Application Reference Number:	2026/0120
--------------------------------------	-----------

Proposal Description:	(RETROSPECTIVE) Change of use from dwellinghouse (Use Class C3) to small HMO (Use Class C4).
------------------------------	--

Location:	32 Dodworth Road, Barnsley, S70 6DY
------------------	-------------------------------------

PROPOSED FIRST FLOOR PLAN

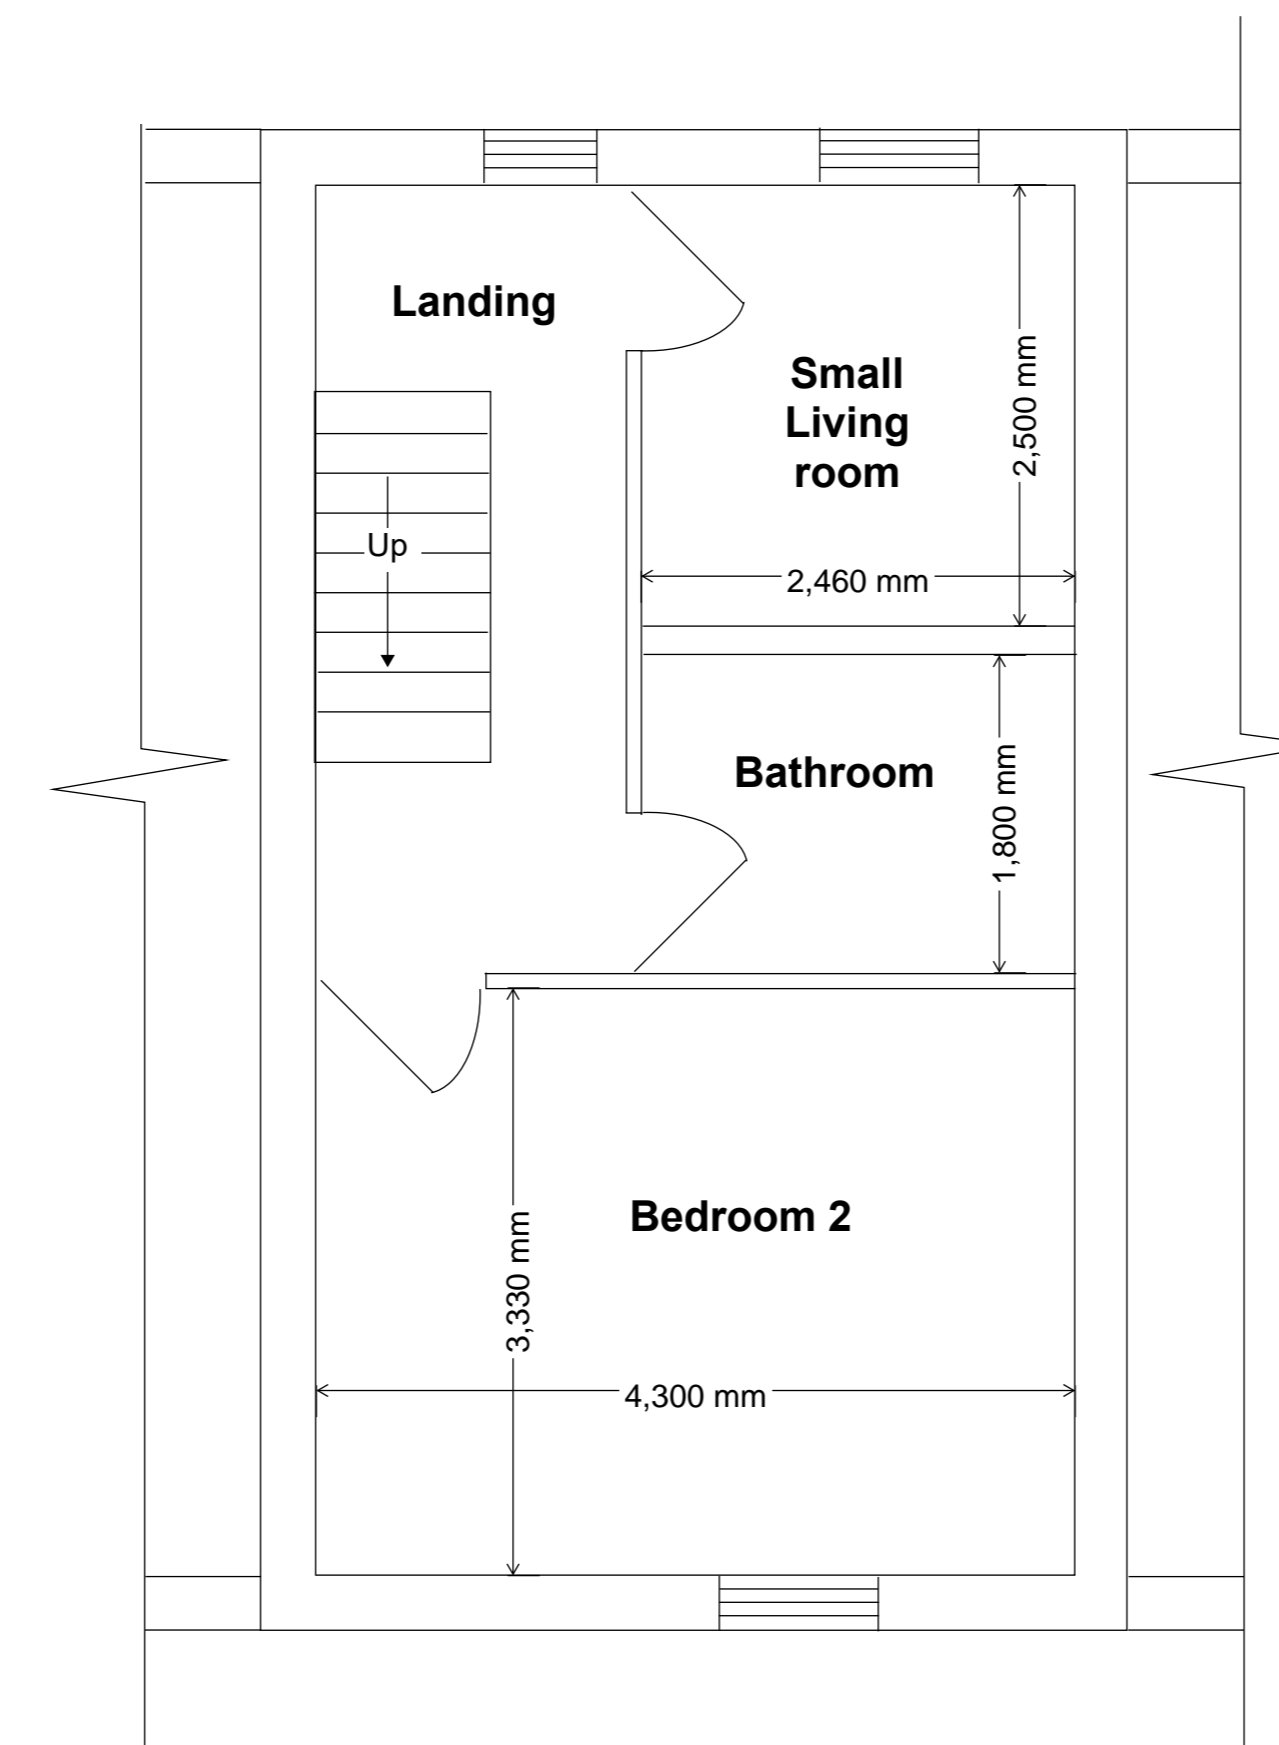
Case Management Officer – Initially raised some concerns regarding the size of existing bedroom 2. In response to this the floorplans have been updated to propose that bedroom to be repurposed to a shared living room. No objection to the property being used as a 4 bedroom HMO on this basis.

The Case Officer Manager has reviewed the proposal in terms of the HMO Licensing requirements and the quality of the internal accommodation for future residents. Initially the HMO was laid out whereby the shared accommodation was on the ground floor and bedrooms 1 and 2 were at the first floor. However, the existing/proposed bedroom 2 was too small to be considered as a suitable HMO bedroom, measuring only 6.5sqm. As such as the proposed layout has been amended so that this room is to be used as a shared living area.

Given the retrospective nature of the proposal, a condition is attached to ensure that the small room on the first floor is converted into a living room within one month of this decision and shall not be used as a HMO bedroom.

- *The proposed floorplan has been updated in response to the Case Management Officer comments in relation to the size of the internal accommodation.*
